Date: 1 May 2024
Our ref: 63971/01/NG/HP/31426769v1
Your ref: PP-12965000

M&S Fosse Park Shopping Centre: Non-Material Amendment to Planning Permission Ref. 23/1020/FUL

Proposed Non-Material Amendments

1 PROPOSED FRONT ELEVATION A  
405 1:100

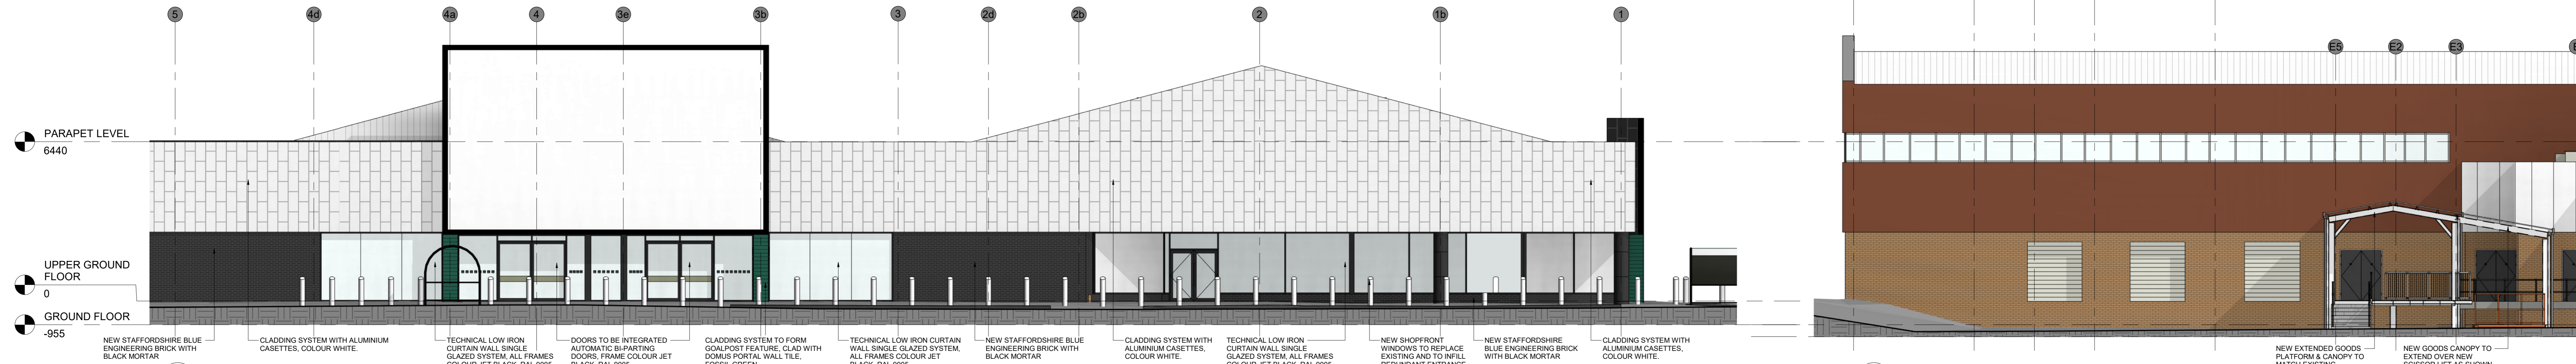
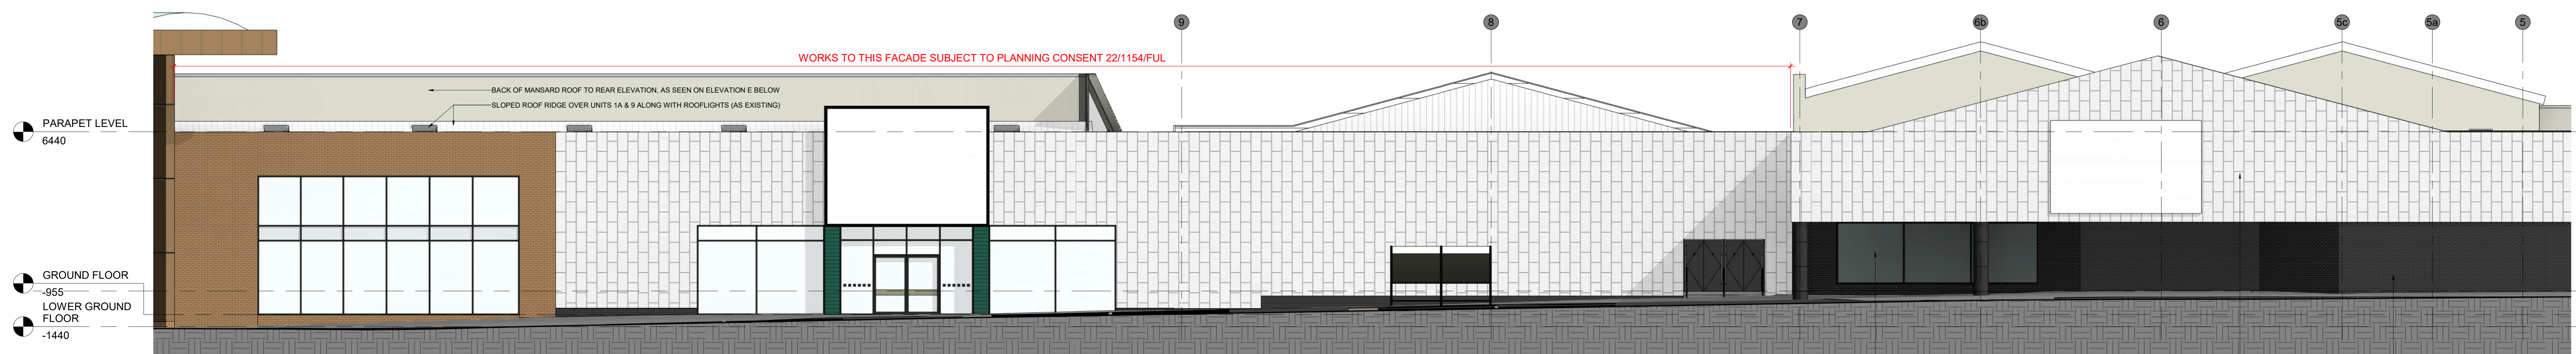
The proposed non-material amendments seek the following improvements to the front (eastern) elevation of the M&S unit:

- Increase the height of glazing above the main entrance by 1,800mm;

- Increase the height of green tiled entrance cladding by 1,800mm; and

- Reduce the height of the associated signage zone at the main entrance by 1,800mm (i.e. top level of advertisement signage zone remains unchanged; bottom level moves up by 1,800mm). The width of the signage zone remains as approved. The proposed reduction in height of the advertisement will result in the signage zone height above ground (measured from base of the advertisement) to be 4,500mm.

The updated façade design at the main store entrance uses high quality materials, is attractive and fit for the future purpose of the M&S unit. Notably, the increased glazing above the M&S unit entrance and reduced signage zone size will increase the amount of active frontage on the front (eastern) elevation, enlivening the main store entrance. Further, the increased height of the green tile cladding at the main entrance is considered to provide an appropriate frame for the entrance, comprising high quality and aesthetic materials. Whilst minimal changes are proposed, the improved design quality is considered to enhance the aesthetic quality of the façade, as demonstrated in the approved and proposed drawings below.
